OBSERVATION/SUBMISSION TO PLANNING APPLICATION

Case Reference: 324113

Re: Observation to the proposed development of open-cycle gas turbine (OCGT) and generator with ancillary equipment.

Location: Pollnagroagh and Rathmorrissety (Townlands), Athenry, Co. Galway

**7.5 METER CCTV POST**

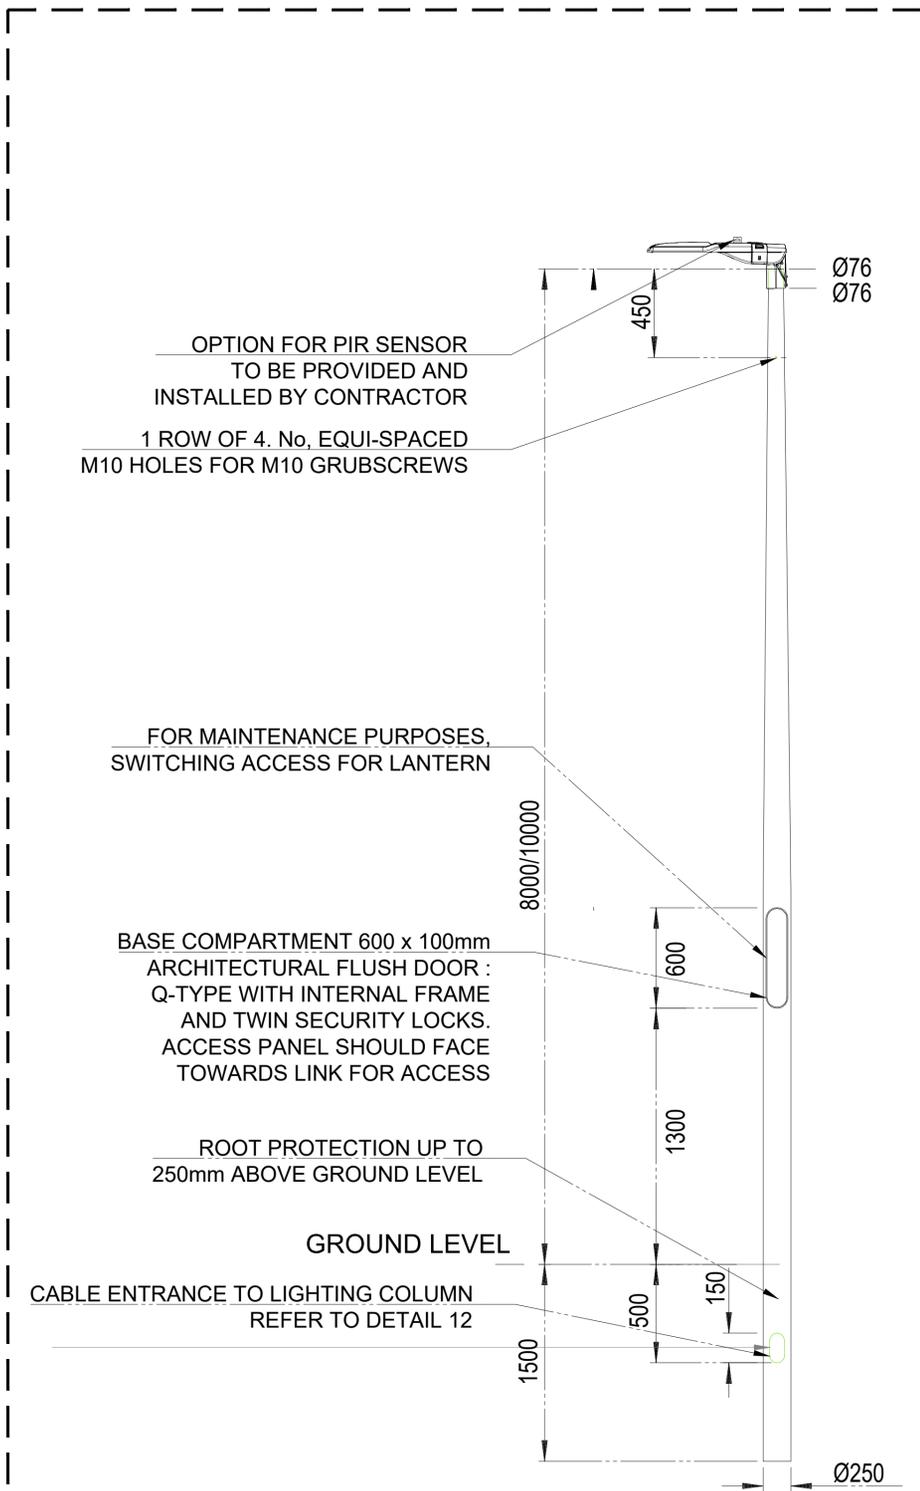
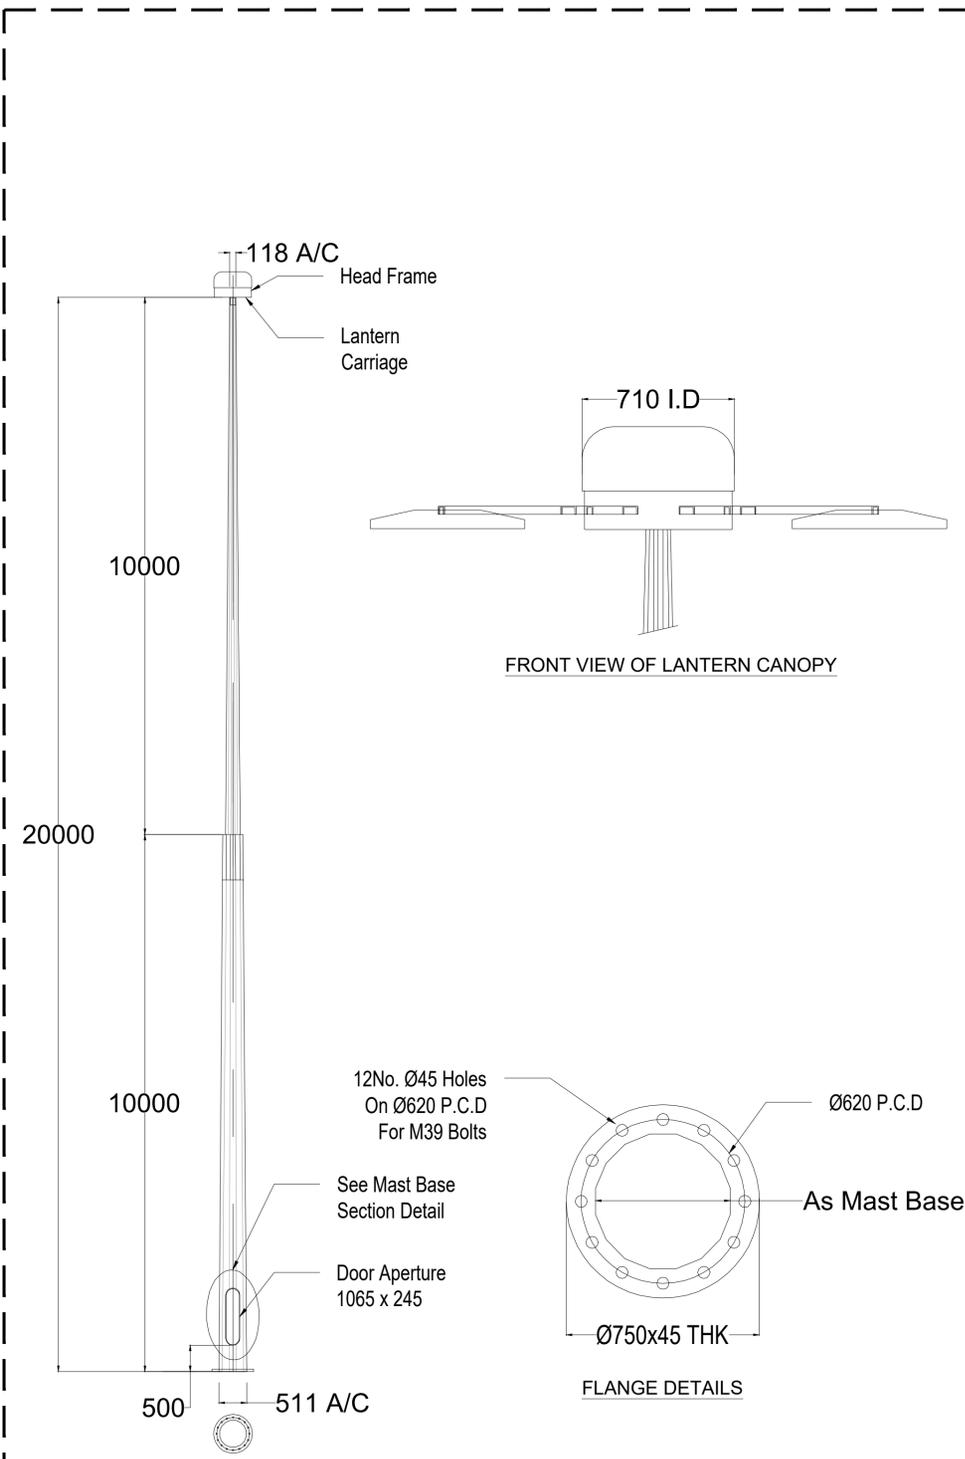
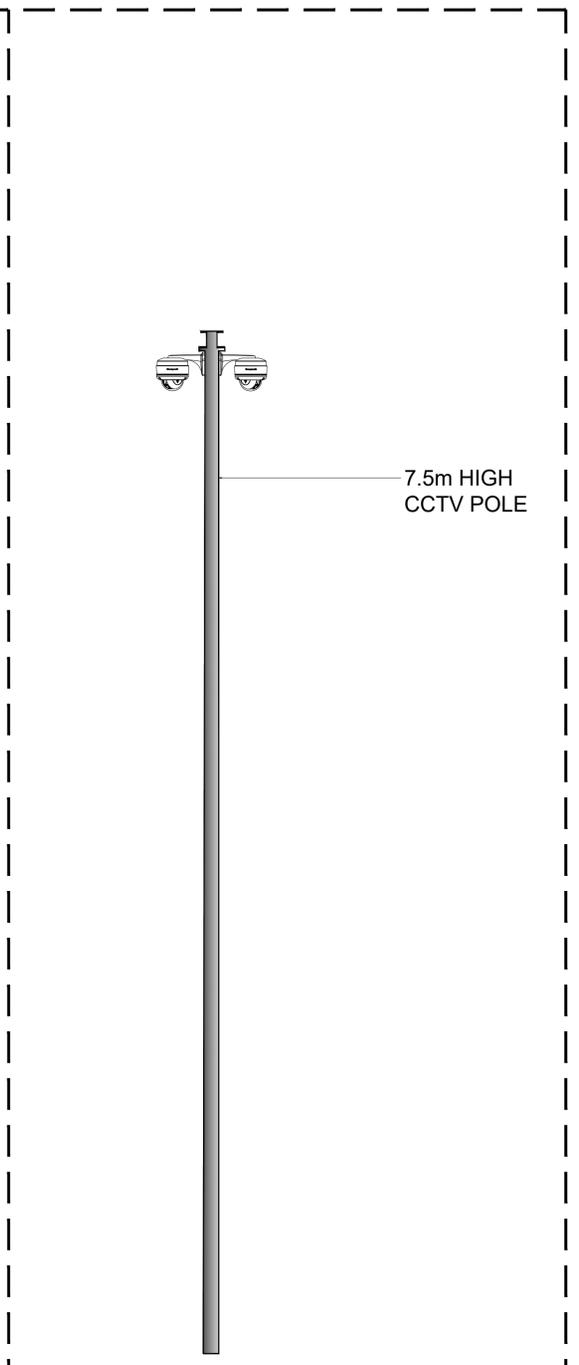
Further, as residents who live in very close proximity to the proposed plant the likely installation of CCTV and security infrastructure raises concerns regarding privacy and data protection. Cameras may inadvertently capture footage of private property or residents going about their daily lives. There is insufficient clarity regarding data management practices, including who has access to footage, how long it is retained, and what
